Permit No: 02-0278 Issue Date: JUN 28 2002 CBL 347 C039001

Location of Construction: 1476 Washington Ave Owner Name: Hurlbise Dana P & Owner Address: 210 Coyle Street CITY OF PORTLAND Phone: 773-0097

Replace Foundation & Rebuild 16' x 34' Structure. kitchen stone foundation with new concrete foundation. Replace 16' x 24' with 16' x 34' structure. legkl Zunft per micropile N/A FIRE DEPT: Approved Denied INSPECTION: Use Group: R-3 Type: 5-B BOCA R99

RE: 1476 Washington Avenue - R-3 zone - 347-C-039

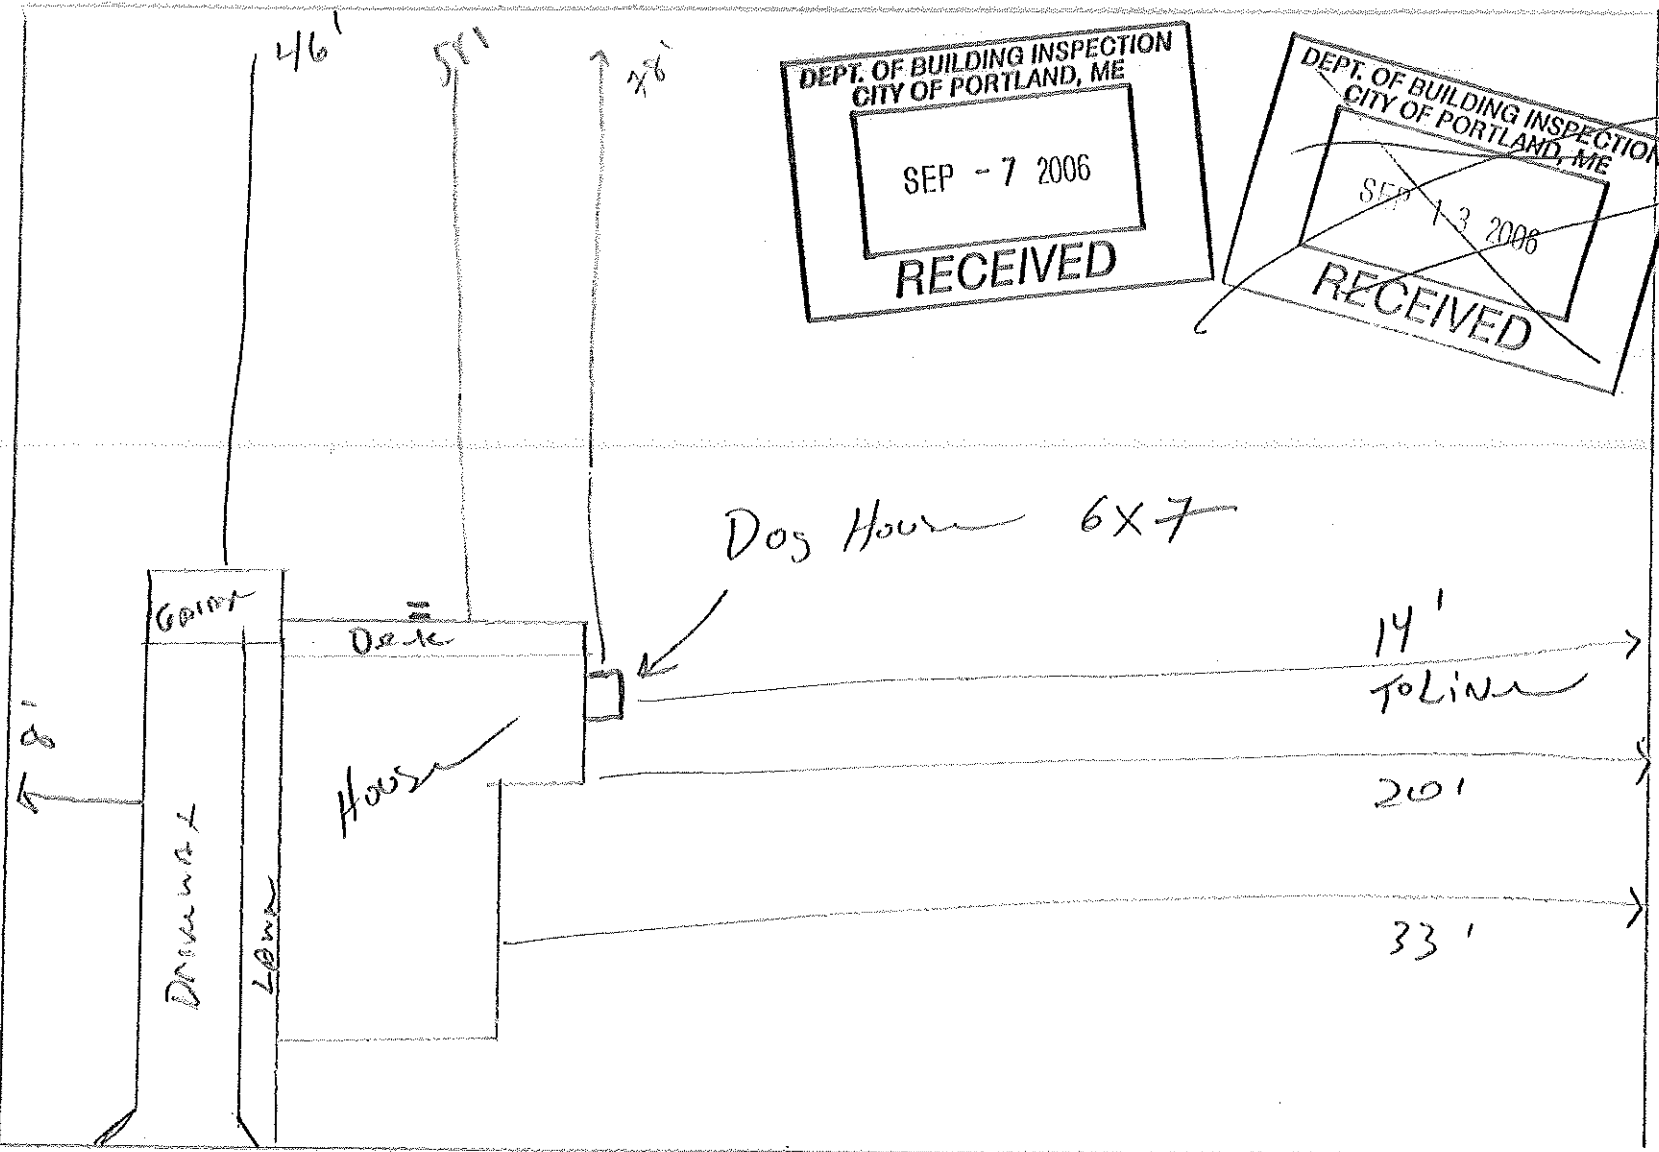
I am in receipt of your permit application to replace a section of structure that has already been demolished. I am confused about the proposed use of this structure. I found no floor plans attached to your submittal. I will required floor plans showing what the use of these floors are.

I will also need an accurate site plan. The one that was submitted can not be accurate. The rear setback given on this plan shows 150' from the rear of the building to the rear property line. The Assessor's plans show the entire lot to be 150' deep. Therefore the setback can not be the same length.

*not with
Dana Hurbise
5/29/02
the submittal
is the submittal floor plans*
